FALCON FIRE PROTECTION DISTRICT

**Re: Conditional Commitment to Provide Emergency Services
Property: Bent Grass East Commercial Filing 3 with Deviation**

March 5, 2021

### PRELIMINARY PLAN

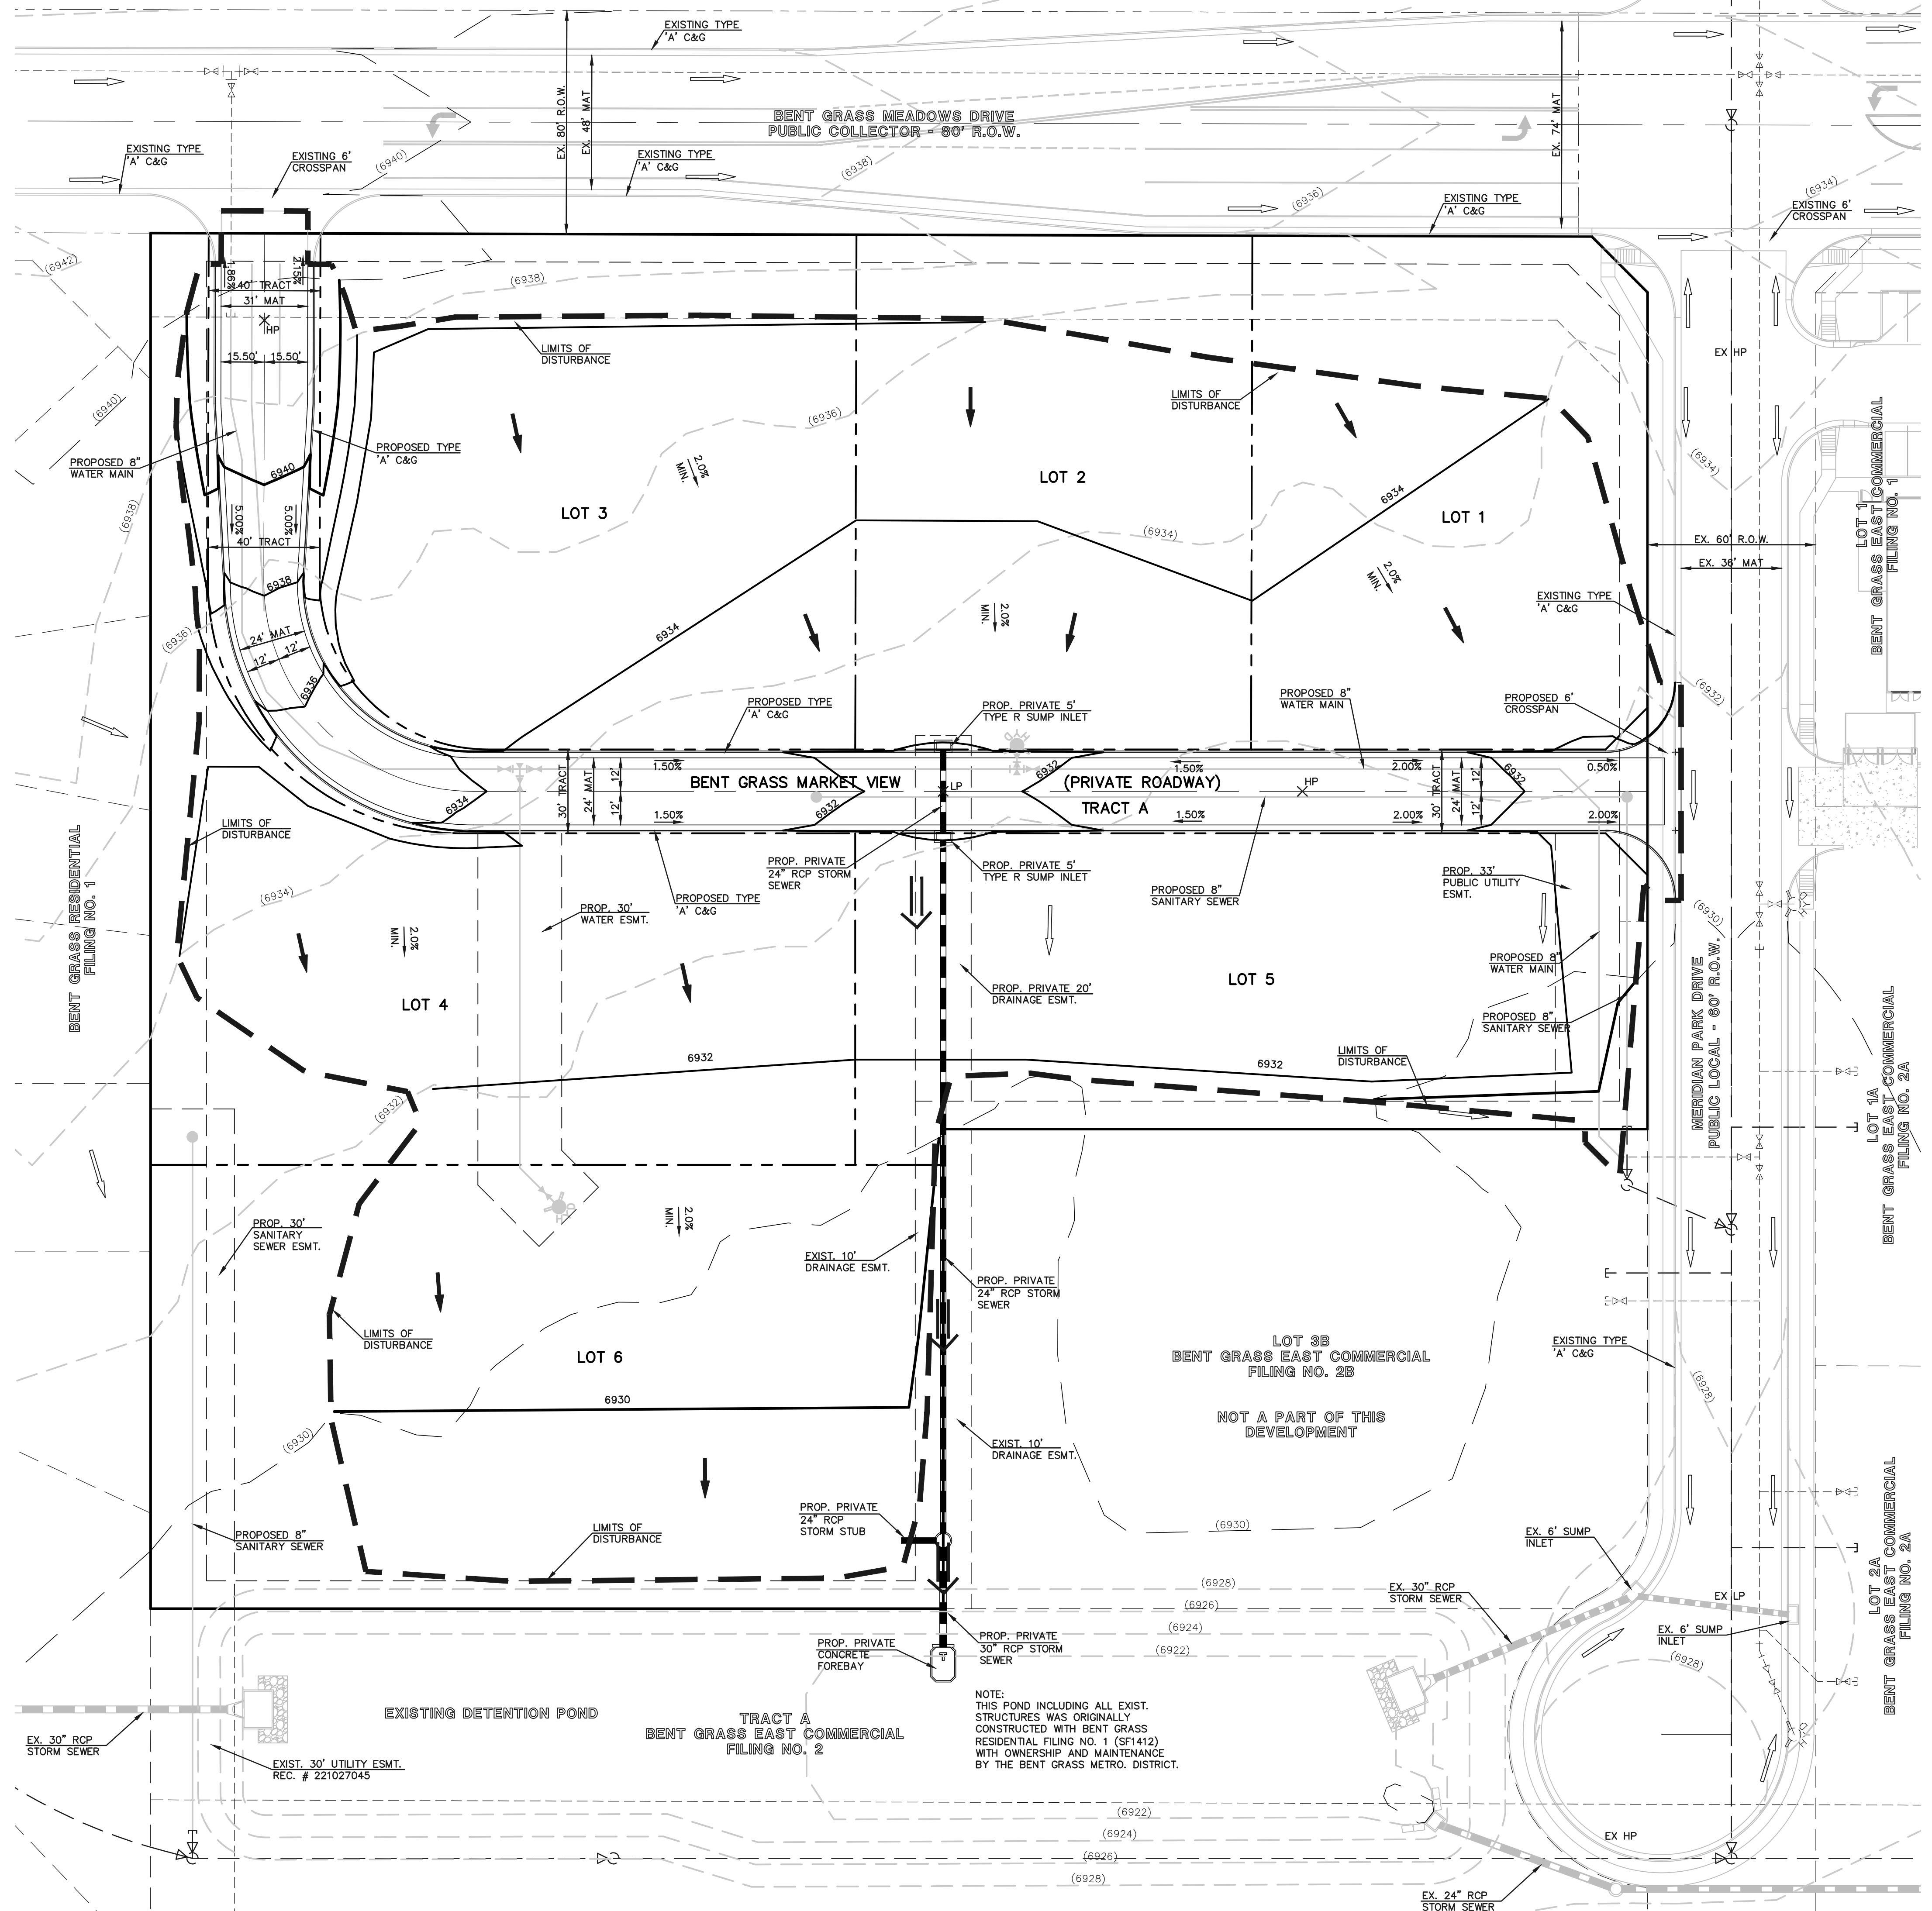
- Falcon Fire has reviewed the deviation request filed with El Paso County Development Services and has the following requirements.
 1. Roads Less Than 28 Feet in Width. Fire apparatus access roads less than 28 feet in width shall be posted on both sides as a fire lane no parking."

2. A minimum turning radius of 33' inside or 44' outside shall be provided throughout.
 3. A maintenance agreement shall be established that provided for snow removal on the private roads to ensure the private roads serving commercial sites are accessible at all times, during all weather conditions.
